From: Martyn White <Martyn.White@arun.gov.uk>
Sent: 14 June 2022 16:57
To: Planning.Responses <Planning.Responses@arun.gov.uk>
Cc: Simon Davis <Simon.Davis@arun.gov.uk>
Subject: BR/93/22/DOC

BR/93/22/DOC

65-71 Upper Bognor Road Bognor Regis PO21 1HR

Approval of details reserved by condition imposed under BR/252/21/PL relating to conditions 8-details of eaves, guttering, materials, window, doors and other external finishes, 10-landscape scheme, 11-boundary treatments, 14-bat and hedgehog nesting facilities and 17-charging of electric vehicles.

DWG NO
1127/P/200

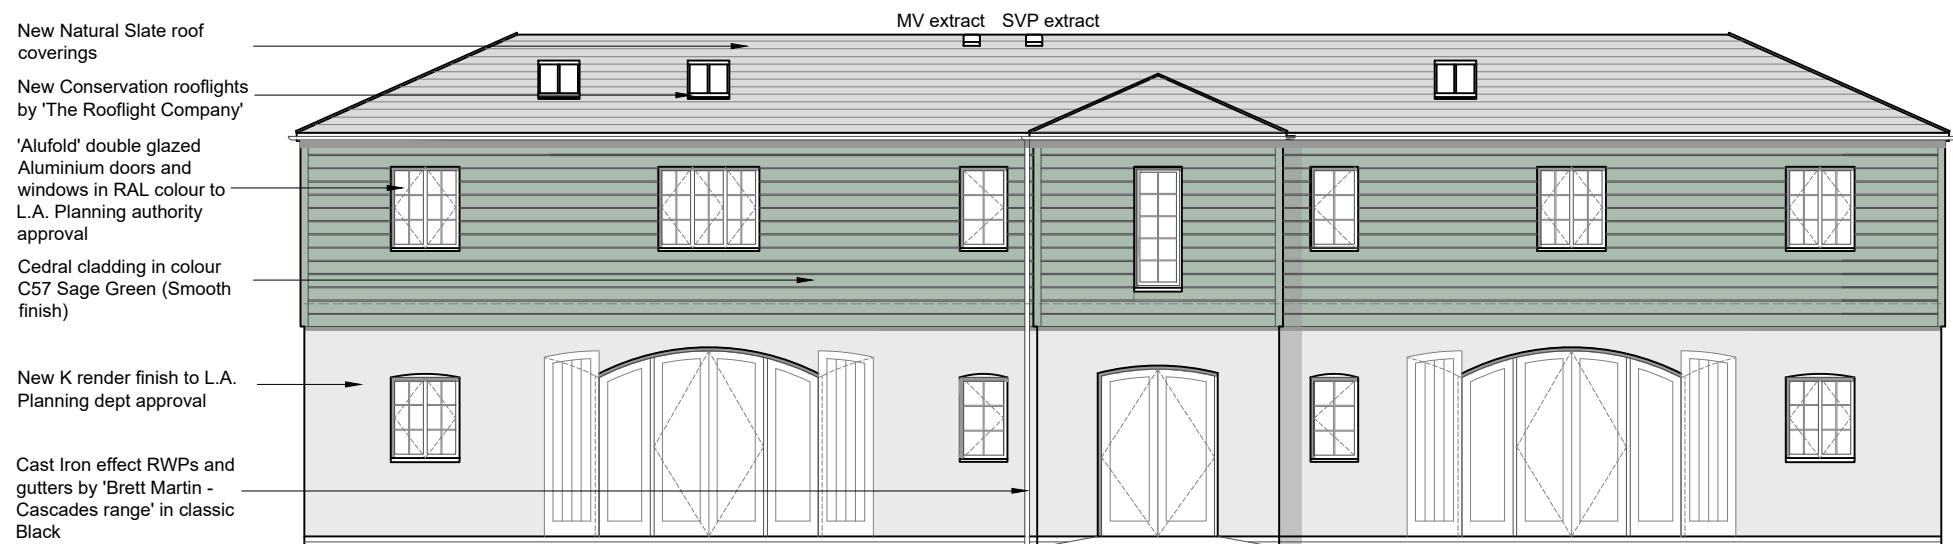
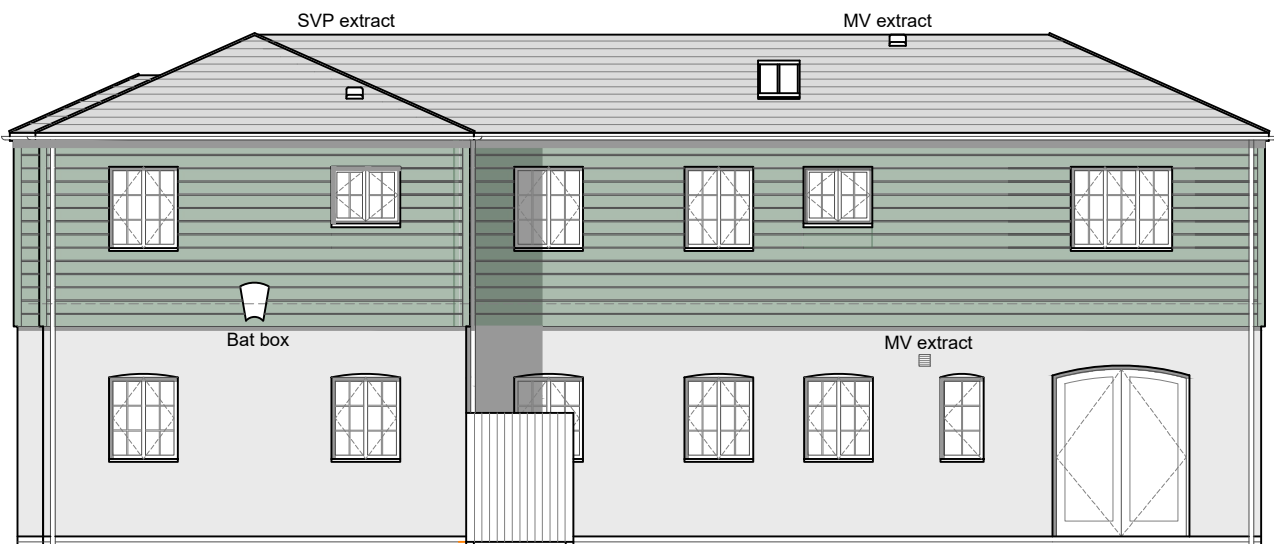
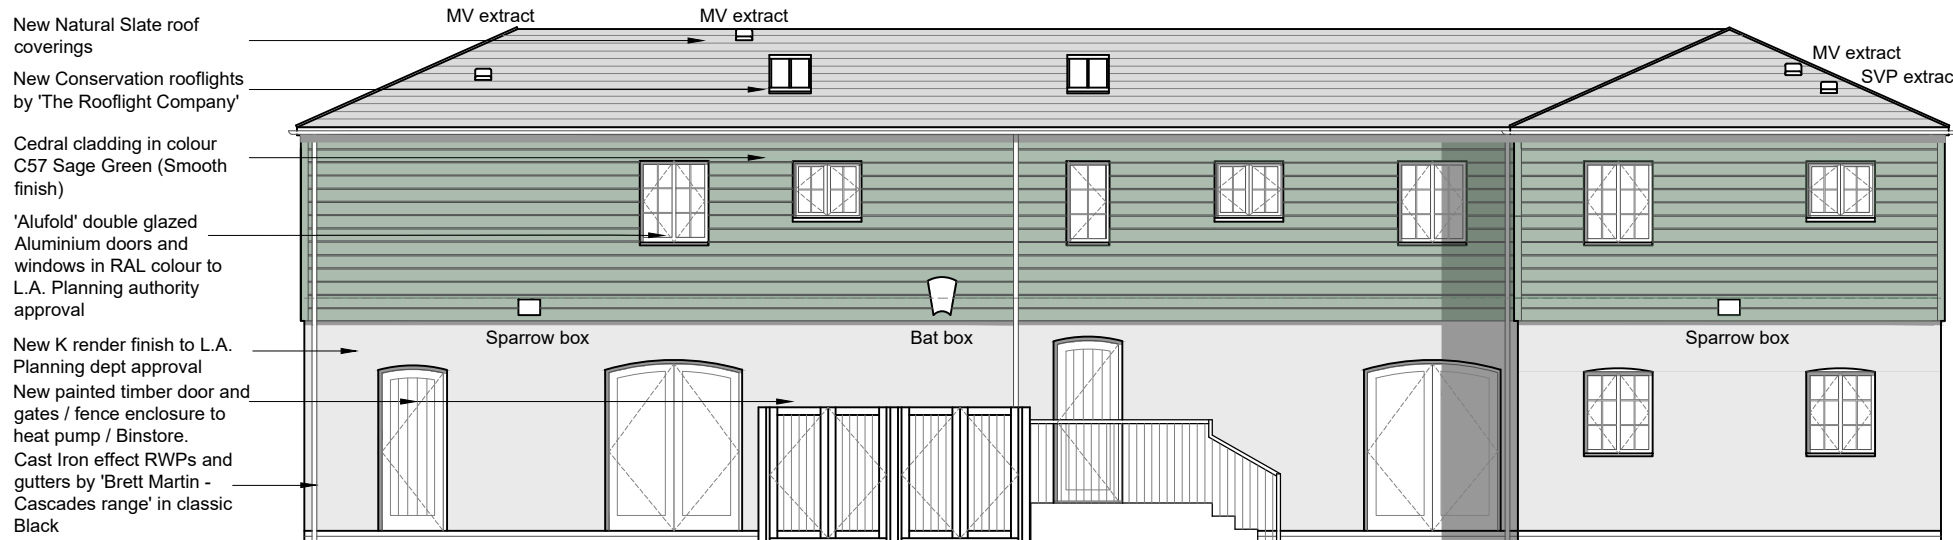
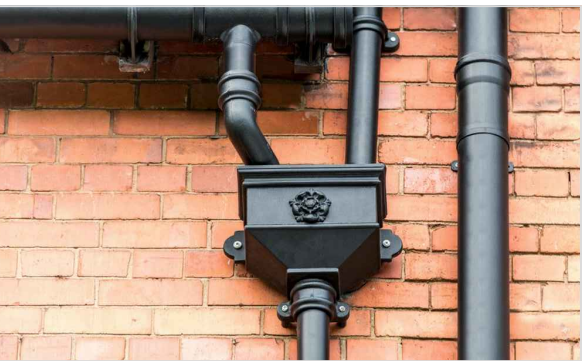
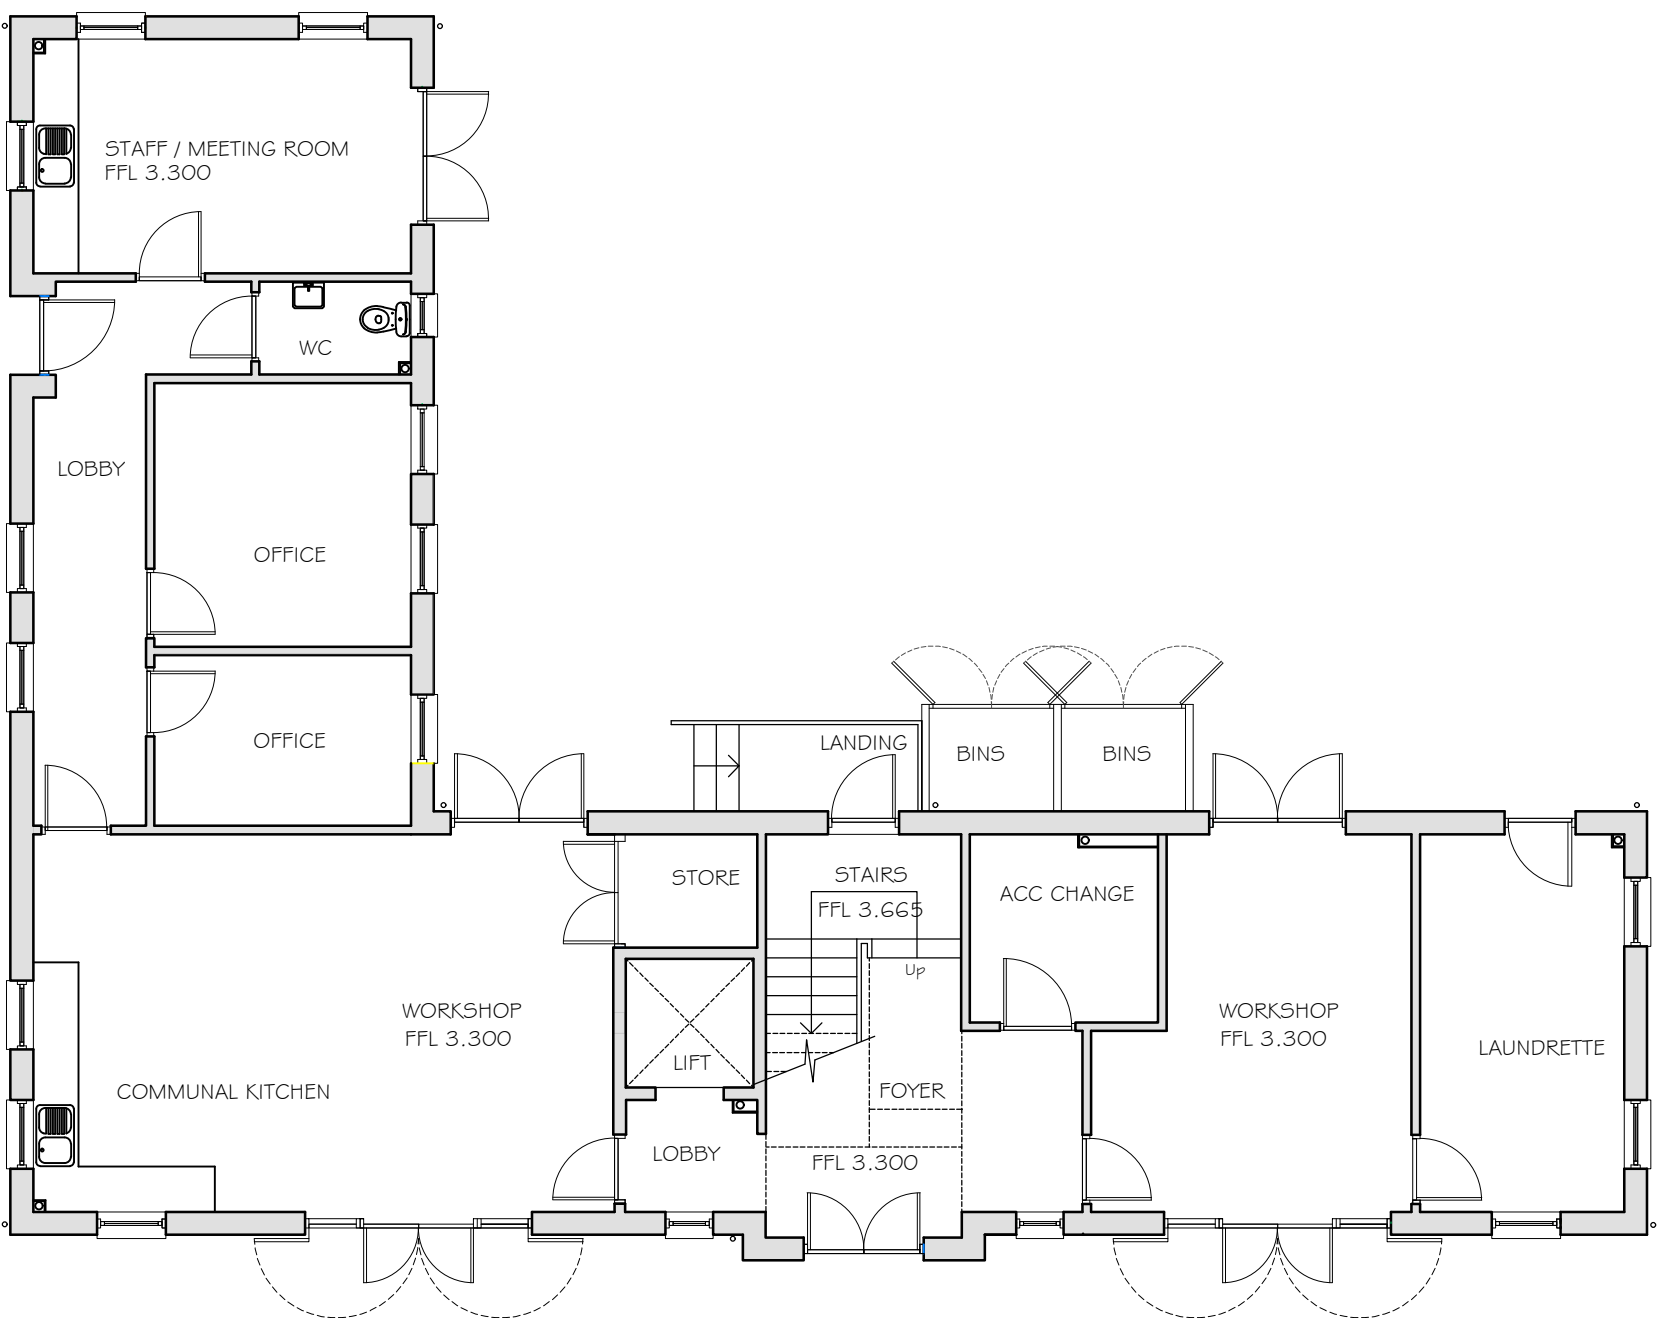
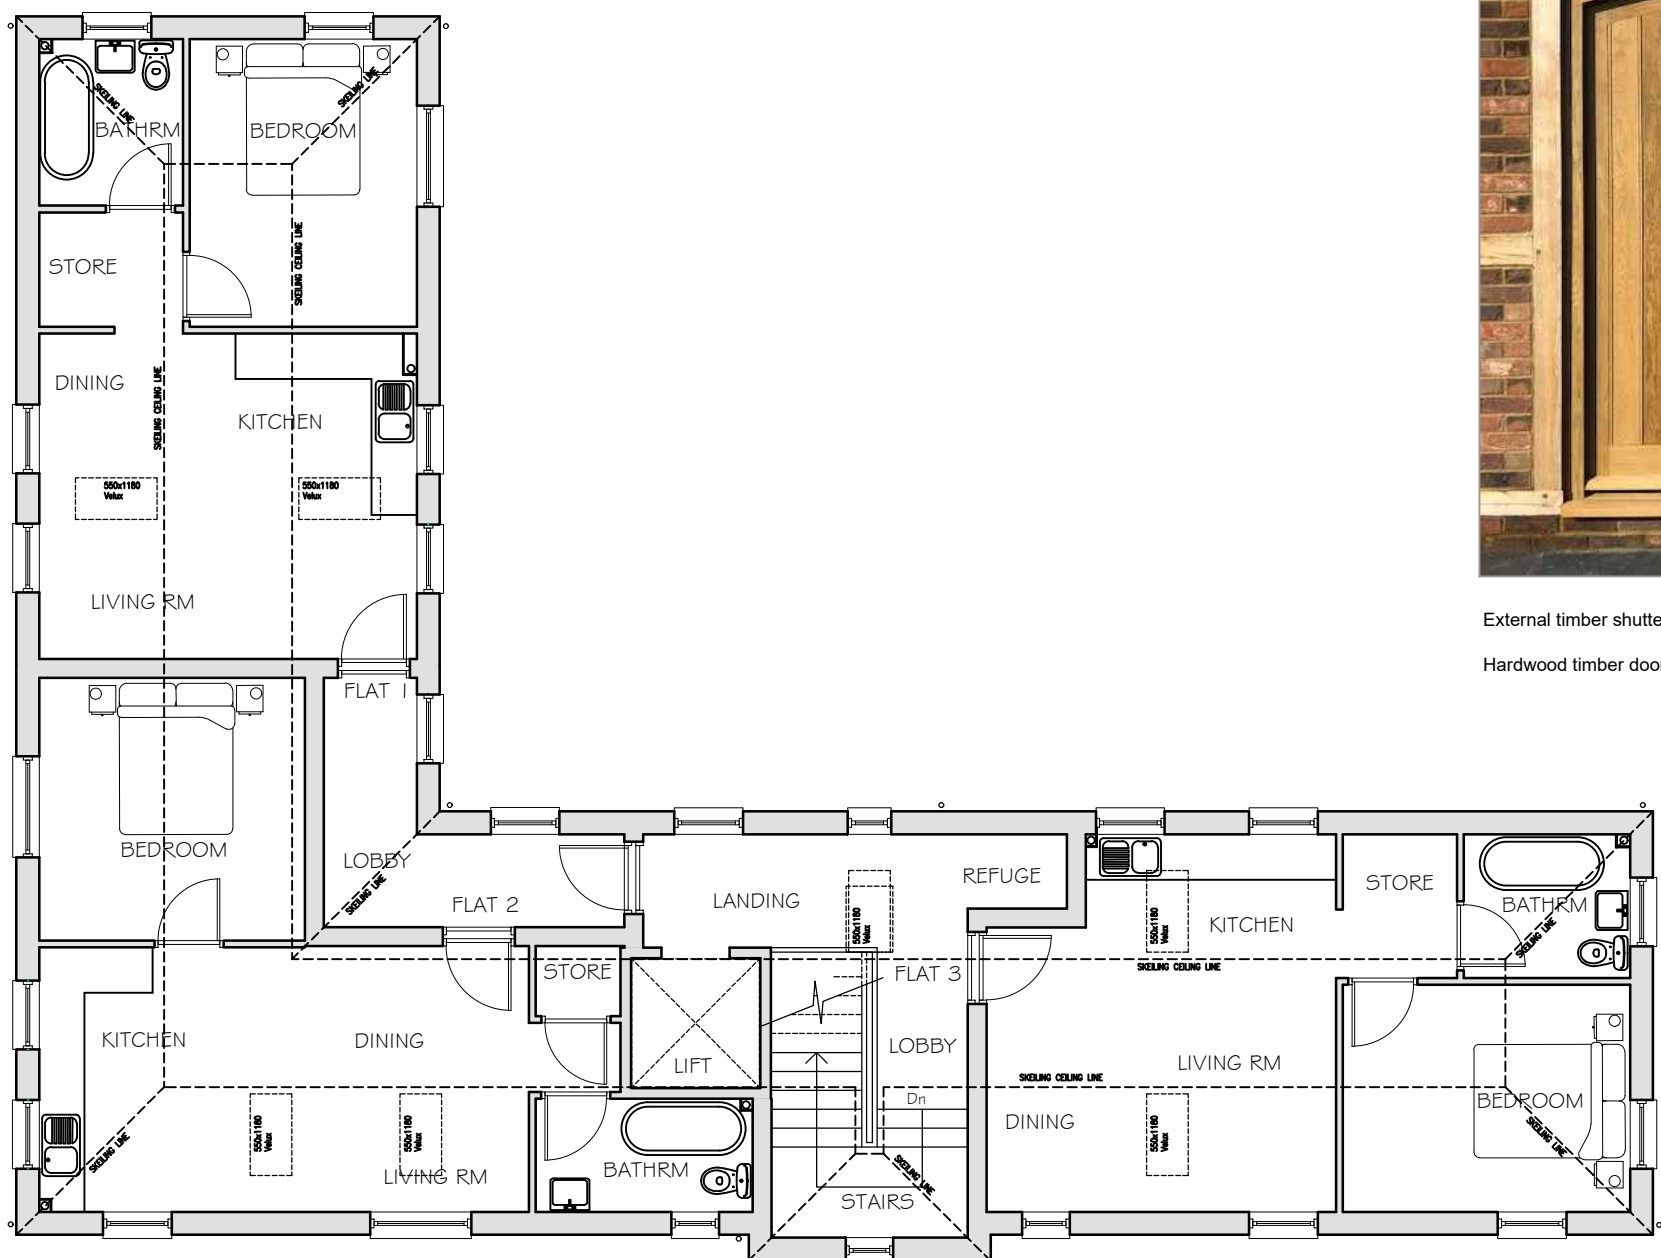
On the topic of windows, I also note that reference is made to the fact that the double glazed Aluminium doors and windows are in a in RAL colour to L.A. Planning authority approval. However, I am unable to see a refence to the proposed colour. I am, sorry if I have missed it!

Looking at the information provided it is clear, first of all, that the elevations of the new building have changed from the plans submitted as part of the planning application. I note that some of the window cills have been raised with the result that those windows are smaller, but also more

importantly note that the elevations are now clad! Not only is cladding not a feature of this locality, but it is also proposed to be in a material which is not appropriate for its sensitive setting, and the colour is not positive either. Such an approach / material / appearance cannot be supported.

I was under the impression that black cast iron gutters and down pipes were proposed, but I note that this is to be replaced with cast iron effect. The style seems acceptable for the new building. I am also unable to find details of the proposed roof coverings, only to a reference that it is to be slate.

Condition 14: The proposed placement of the bat boxes on the new building seem to be acceptable. likewise, the proposed bat boxes on the new extensions to 71/71 a seem acceptable, although no elevation have been provide of the buildings to confirm the exact locations. I am happy with the location of the hedgehog nesting facilities.
